Our ref: CE/2009/103015/01-L01
Your ref: 3/2009/0791
Date: 14 October 2009

**PROPOSED MIXED USE DEVELOPMENT COMPRISING VOCATIONAL
LEARNING CENTRE, CHILDREN'S NURSERY, COMMERCIAL ELEMENT, 10
LIVE/WORK UNITS AND 70 RESIDENTIAL UNITS
LAND AT BARROW BROOK, BARROW, CLITHEROE**

We OBJECT to the proposed development as submitted on the following grounds:-

2.1 Proposed Site Plan.

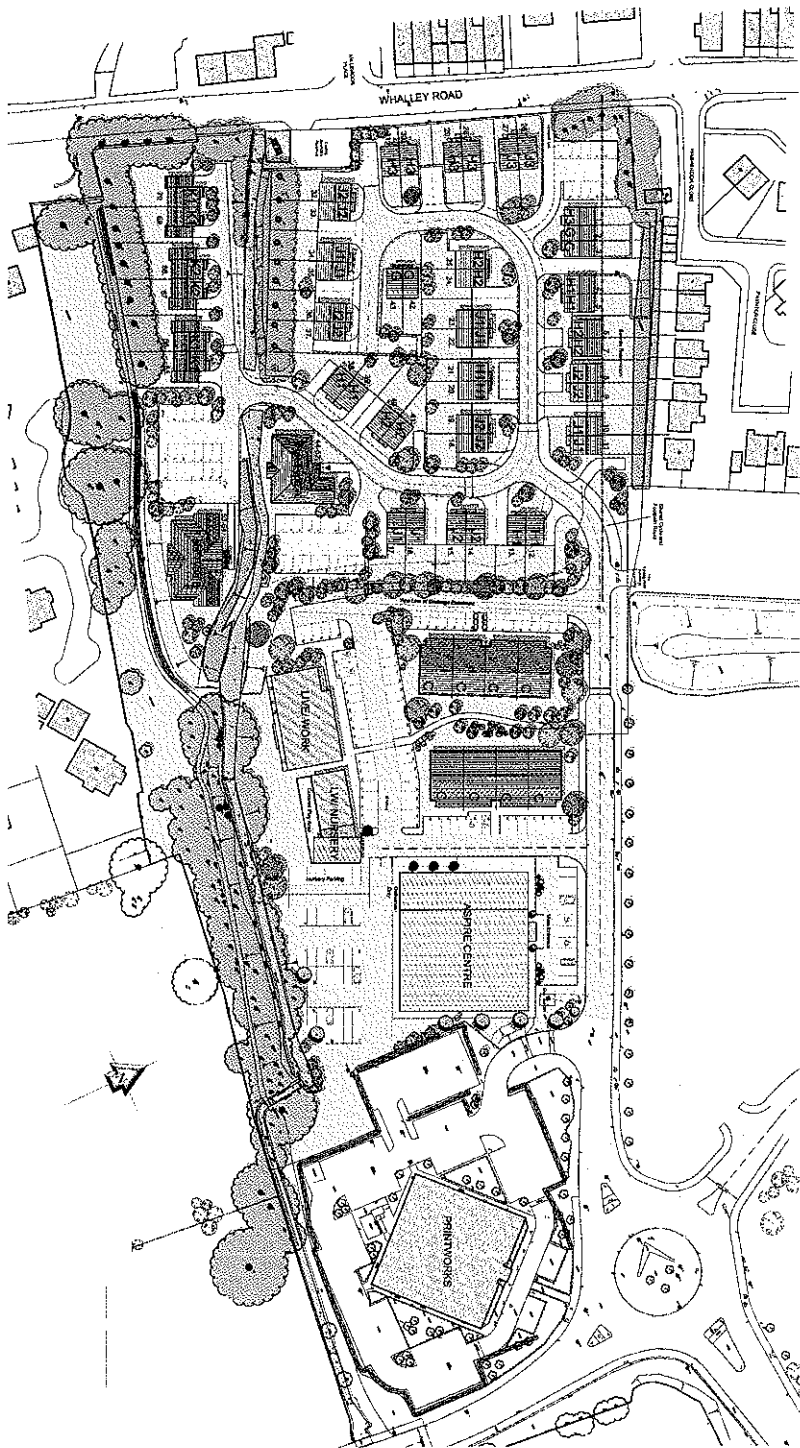
Based on the site layout plan, drawing number 1506-300 the proposed development appears to encroach onto the watercourse and may subsequently have an adverse impact on the river corridor due to its close proximity to the watercourse. This includes the rear gardens of units 32-37, and a block of flats (units 44-52) and associated parking.

The previous application 3/2007/1144 allowed for a greater distance between the proposed buildings and the watercourse. To overcome our objection the developer should submit a revised layout which allows for a buffer zone between the top of bank of the watercourse and any buildings or car parking or private garden space. As such we require further detail of this buffer strip to ensure that the development does not encroach onto the river corridor. We would recommend a buffer strip of at least 4 metres in width.

We would still recommend that a minimum easement of 4 metres between the watercourse and any buildings is retained, both for ecological purposes and for future access to the watercourse for maintenance and/or repair. The vegetation within this 4 metre buffer should consist of the existing habitats on the site and not contain introduced non-native landscaping. Taking this into account, we also recommend the following condition:-
